From: Nolan, Chris <Chris.Nolan@lancashire.gov.uk>
Sent: 15 November 2017 10:54
To: Harriet McCartney; planning
Cc: LHS Customer Service
Subject: D3.2017.0993 - 22 Shireburn Avenue Clitheroe

Planning Application No: 3/2017/0993

Proposal: Removal of garage and erection of new integral garage with single storey rear and loft extension.

Location: 22 Shireburn Avenue Clitheroe BB7 2PN

A	Amendment to suit highways requirements	J.L.	21.11
---	---	------	-------

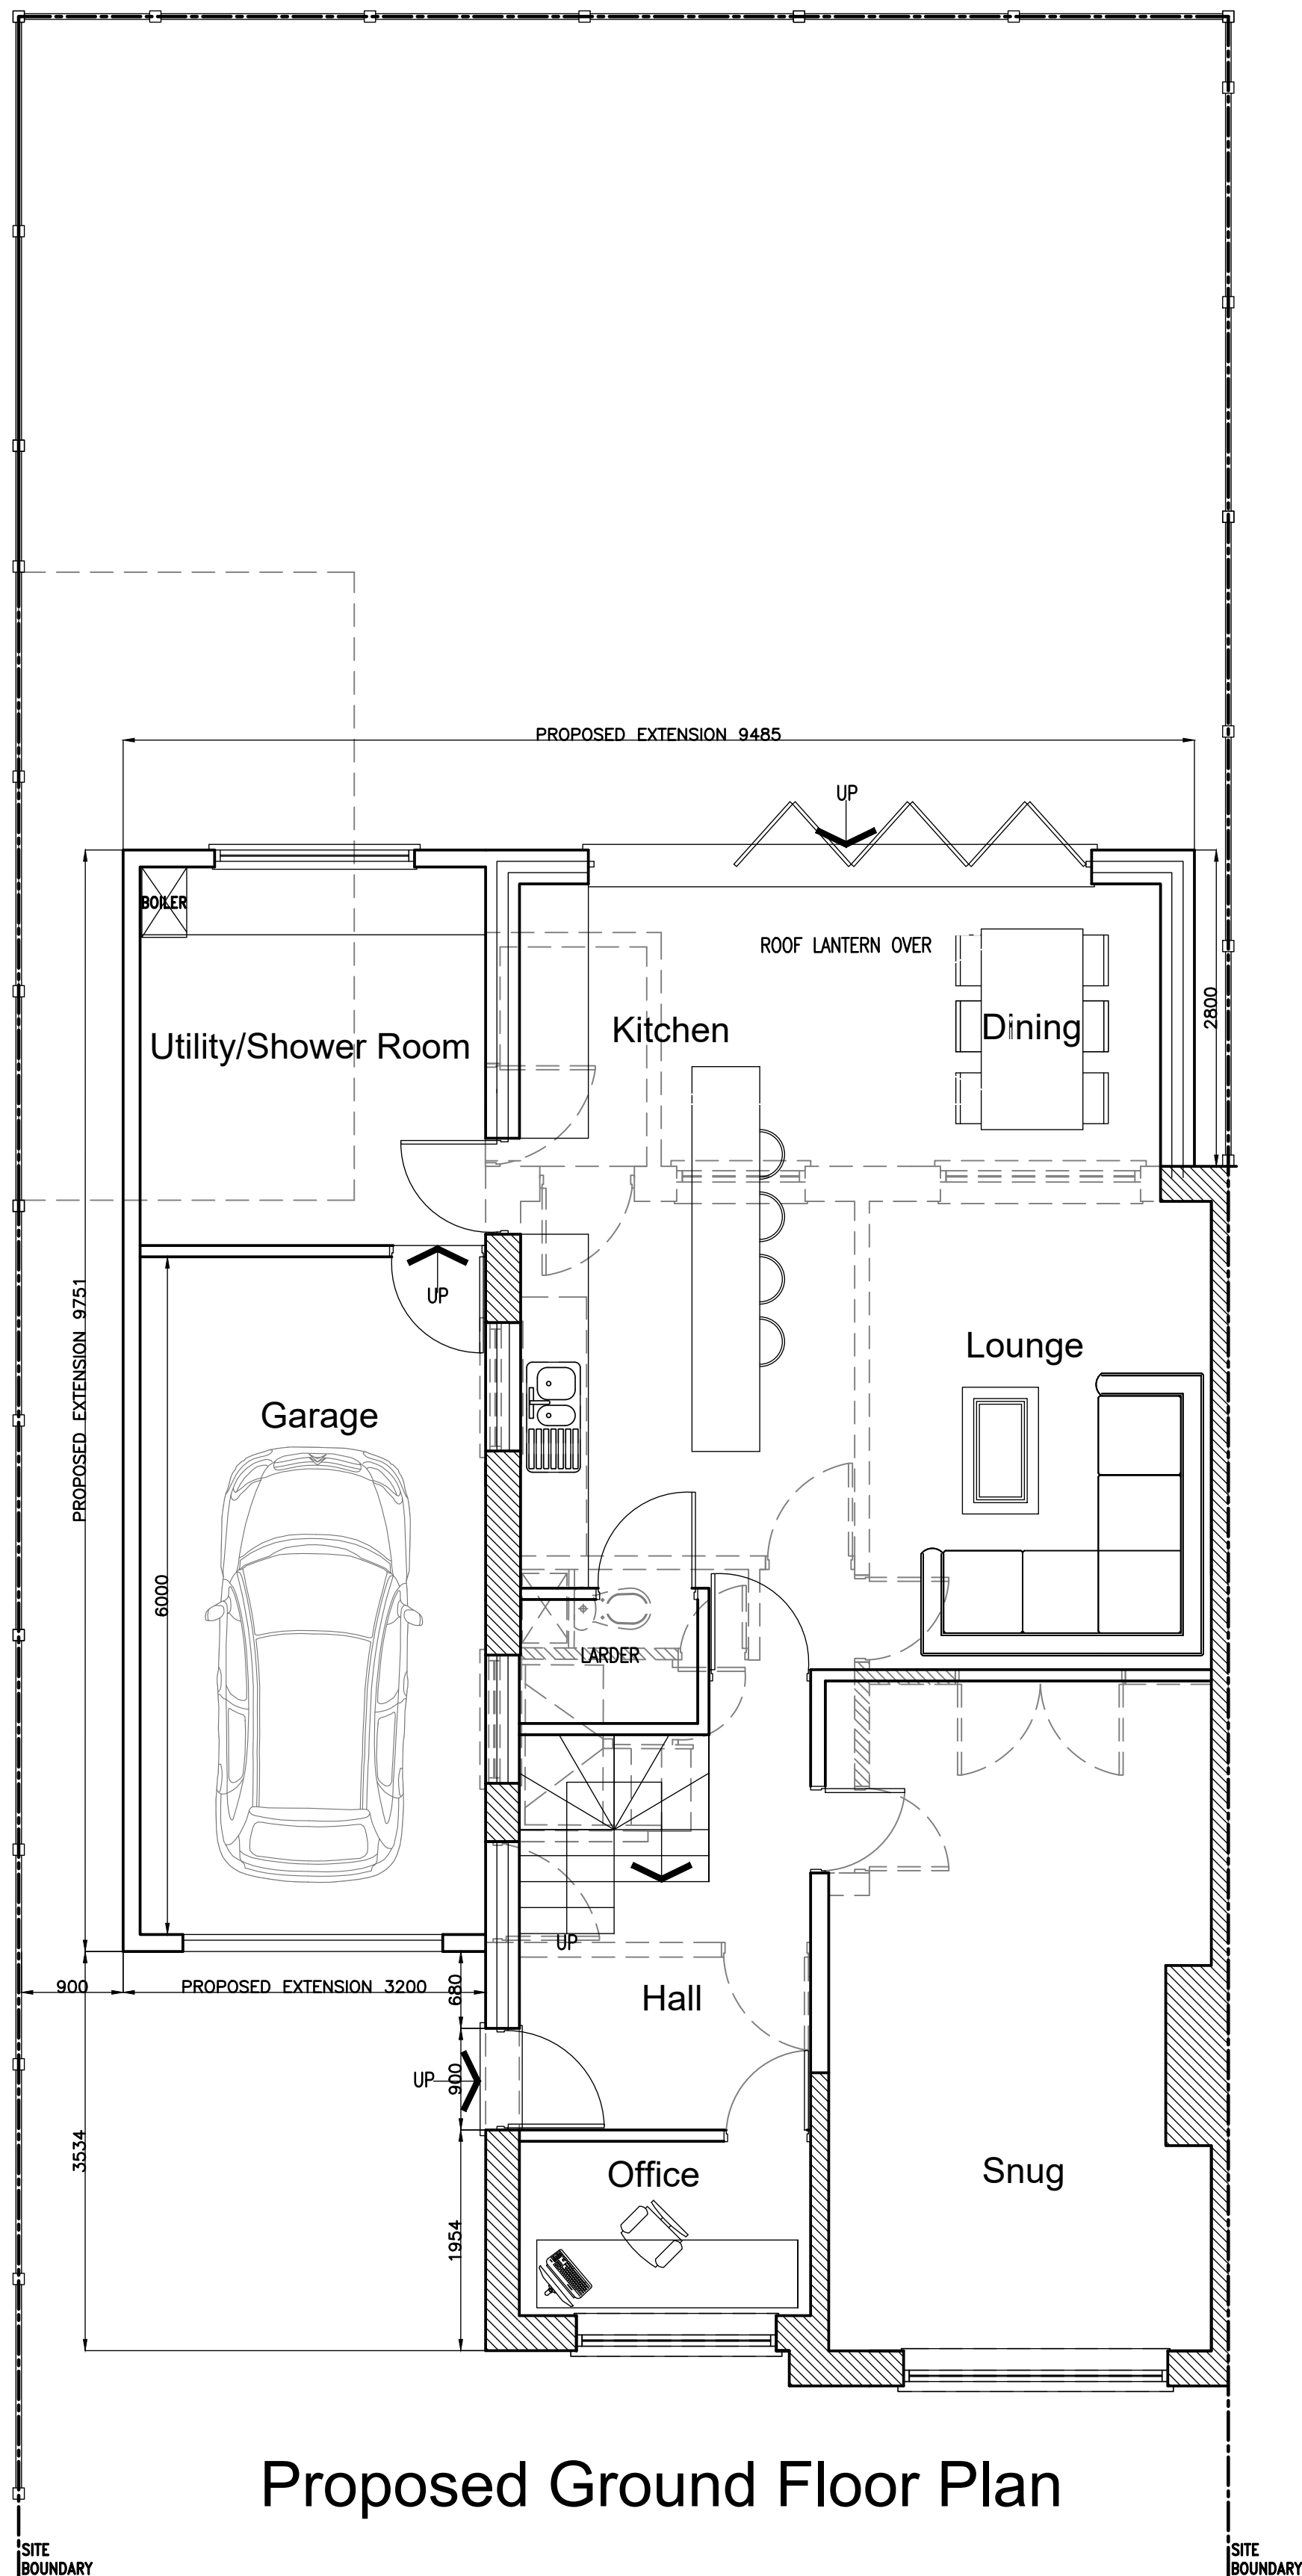
With regard to the above planning application. The proposal will increase the number of bedrooms from three to four whilst also making changes to the available parking. The plans indicate that the work will include the formation of a new garage space whilst removing the existing garage along with access to the existing garage. For a property with four bedrooms I would be look for sufficient parking for a total of three vehicles with in the curtilage of the property. Presently I do not have any plans indicating that this arrangement has been considered or is available.

The plans also indicate that the finished building will occupy the full width of the plot of 22 Shireburn Avenue. As this is the case I would need the plans of the parking arrangements to include plans for where bins are to be stored, to ensure that these do not compromise any of the necessary parking arrangements.

Proposed Site Plan

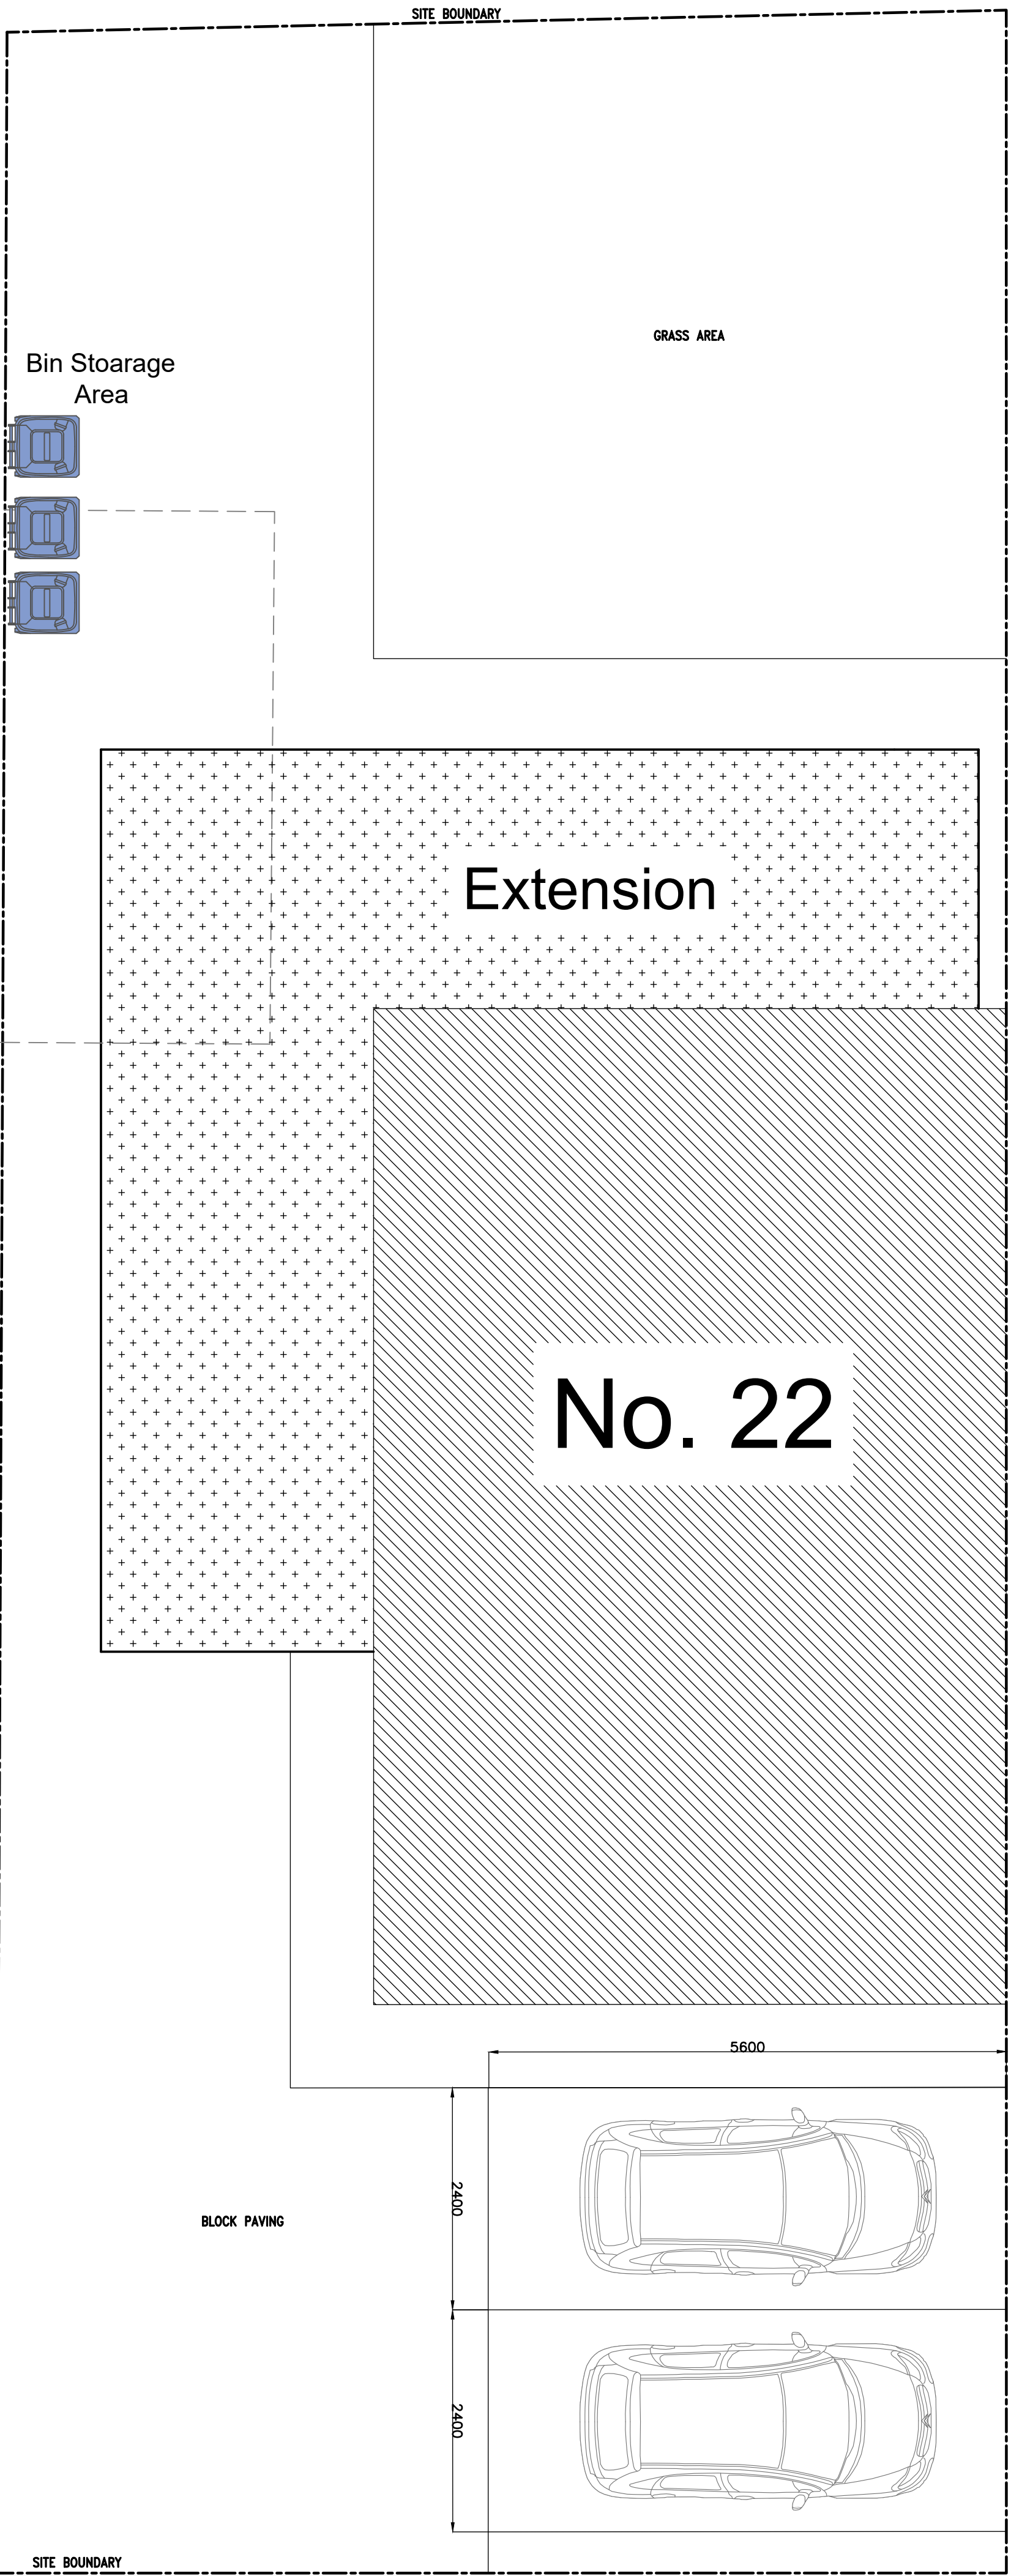
For parking bays I would look at a nominal size of a bay as 4.8m X 2.4m, Where this bay is on a drive that borders on to a highway I would require an extra 0.8m (total of 5.6m X 2.4m) to ensure that vehicles can be parked without the need to protrude on to the highway. Any space required to open garage doors will also be discounted as unavailable for parking, though up and over doors will be considered as not requiring as much space. A garage space, to be counted as a parking bay, should have minimum internal dimensions of 3m X 6m to allow for a car along with other items generally stored in a garage such as bicycles. Before I can be assured that the property, post development, has sufficient parking for three vehicles within the curtilage of the property I would need plans indicating the available parking.

At present I will have to object to this development on highway grounds, as I do not have sufficient evidence that there will be parking available for three vehicles within the curtilage of the property. I will be able to look at this application again if acceptable plans including the parking arrangements and the bin storage are provide.
